Our ref: NO/2012/104466/02-L01
Your ref: 3/2012/0910

Date: 21 January 2013

PROPOSED CHANGE OF USE OF LAND FOR THE SITING OF 15 NEW STATIC HOLIDAY CARAVANS IN PLACE OF THE STORAGE AREA WHICH WILL BE RELOCATED (REVISED LAYOUT) - BRIDGE HEYWOOD CARAVAN PARK, DUNKIRK FARM, WHALLEY ROAD.

Drawing file: planx_downloads / 12_0910_Proposed_sections.pdf

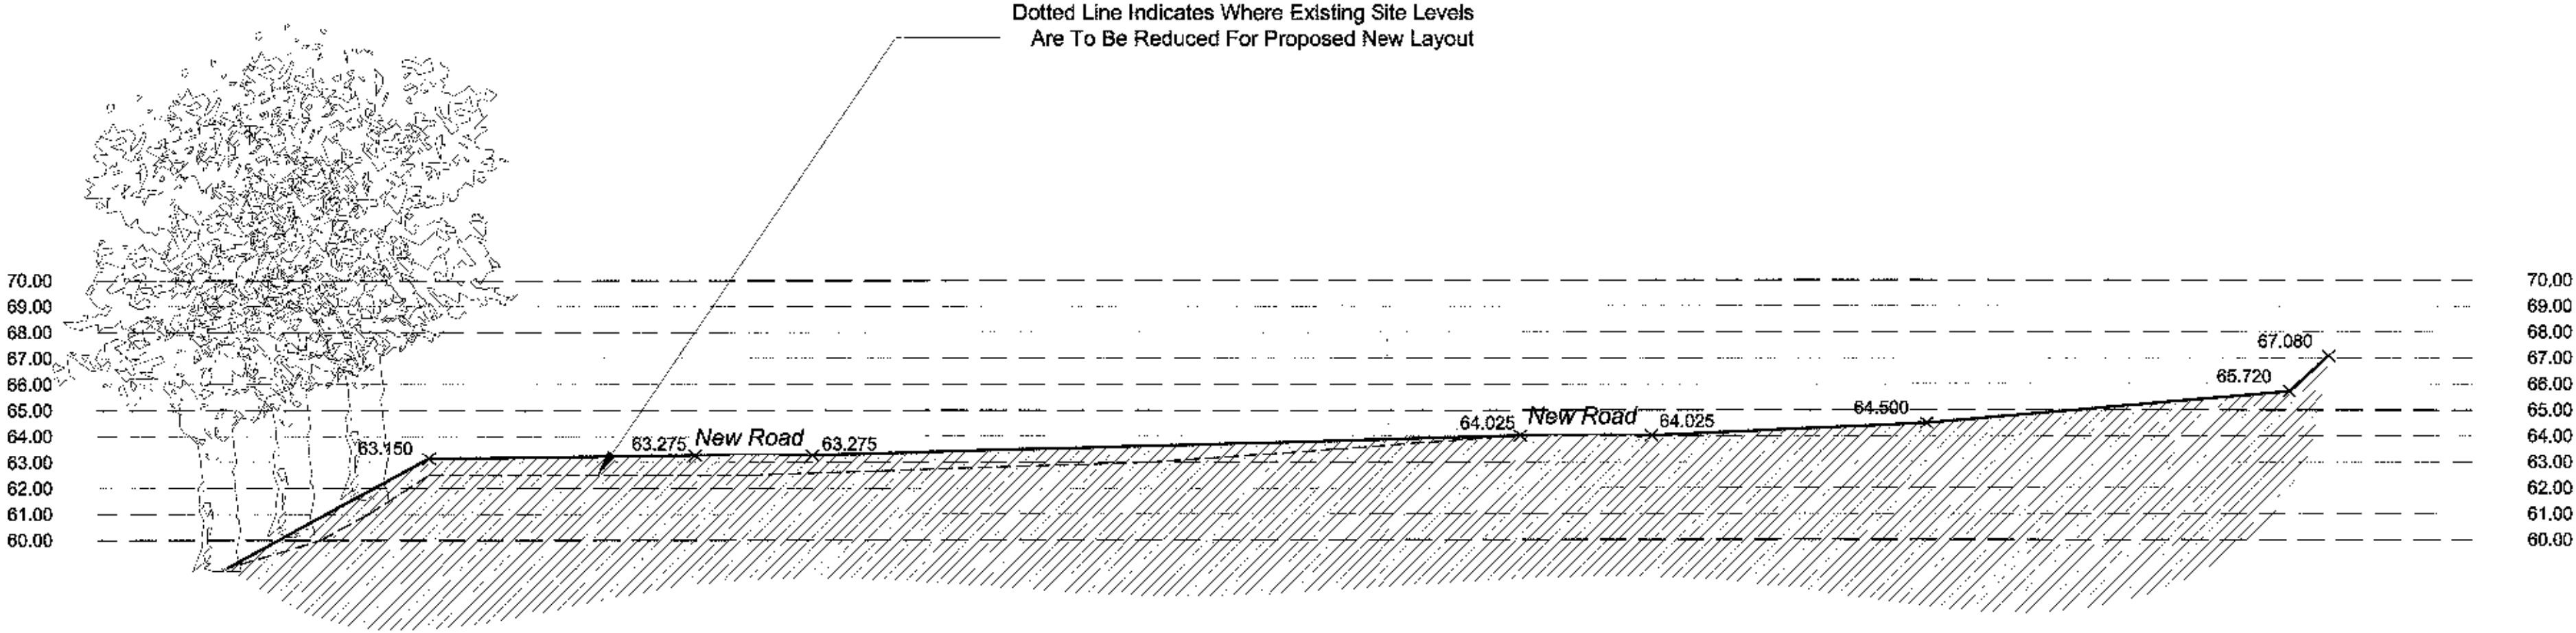
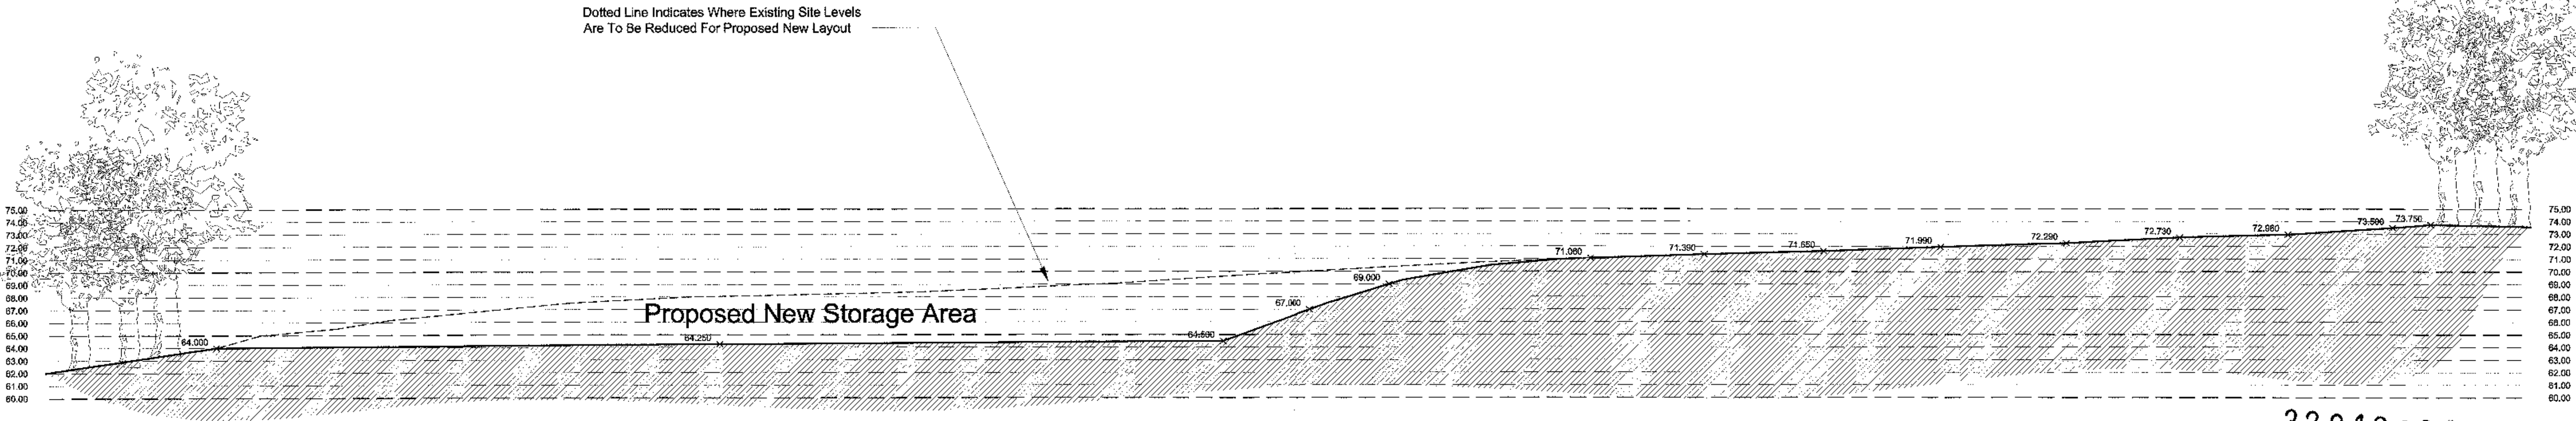
3. *Development shall be in accordance with Drawing No. 502 Revision E Site Layout As Proposed, and Drawing No. 503 Revision E, Site Sections As Proposed.*

1. *To prevent flooding by ensuring the satisfactory storage of/disposal of surface water from the site.*
2. *To ensure that the developments are appropriately flood proof and flood resilient and ensure that surface water is appropriately dealt with.*
3. *To reduce the risk of flooding to the proposed development and future occupants by siting development outside Flood Zone 3.*
